SYDNEY OLYMPIC PARK SITE 53

DEVELOPMENT APPLICATION - ARCHITECTURAL REPORT AND DESIGN VERIFICATION STATEMENT
 PREPARED BY BVN 17 MARCH 2016

BUILDING HEIGHTS - NONCOMPLIANT

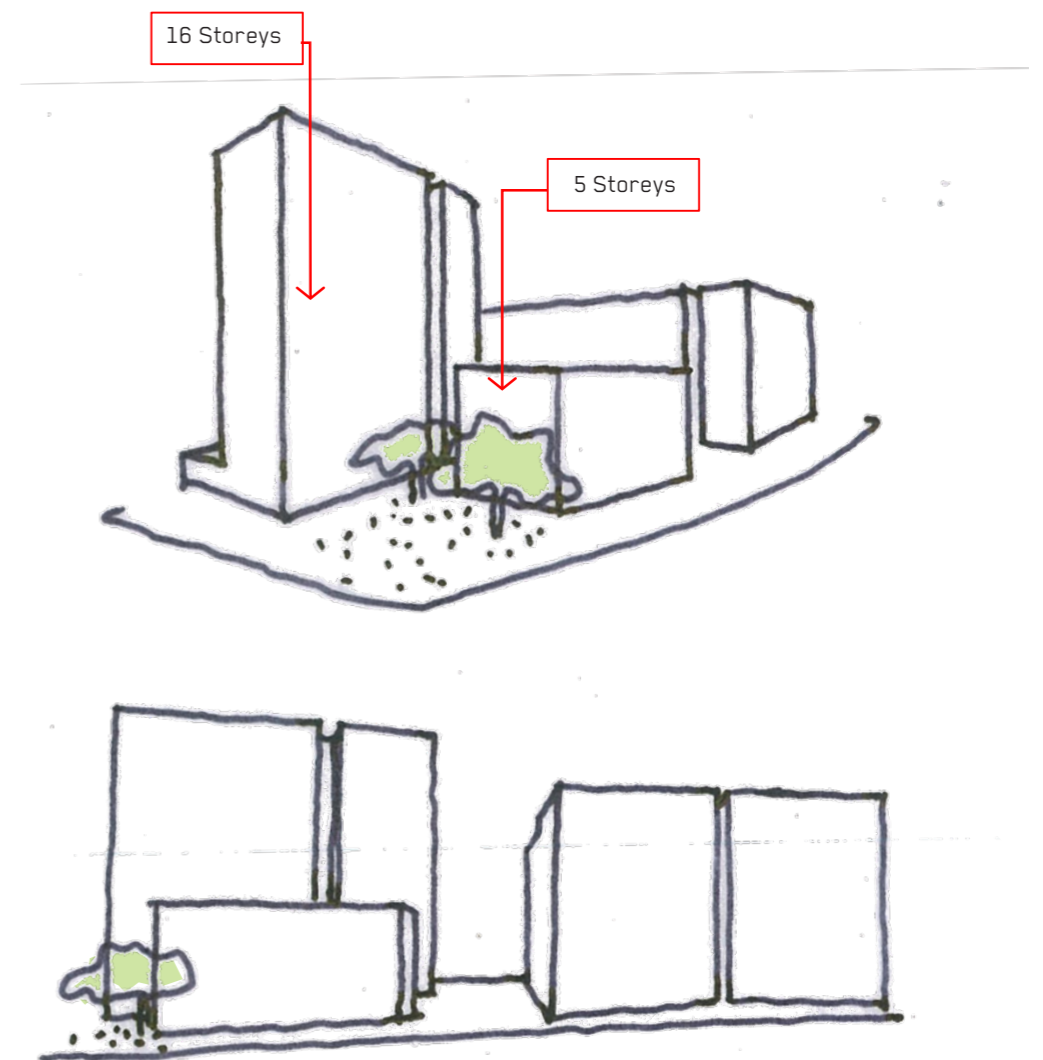
- The Design Jury supported the intention and urban design merit associated with the redistribution of floor space from the northern building to the southern building, However, the Jury considered the scale of the proposed 16-storey southern building to be too imposing and asked that consideration should be given to the height and massing of each building in order to achieve a successful balance.

- The northern building remained at 5 storeys and the southern building was reduced to 15 storeys. In reducing the height to 15 storeys, the building was also moved further south toward the rail line, which had a significant impact on the central garden courtyard by increasing the sunlight in the middle of winter substantially. The 10 storey building which bordered the western side of the view corridor through the site was separated into 2 forms, which broke down the scale and provided visual and physical access to the garden at the west, thereby significantly increasing the size of connected landscaped space.
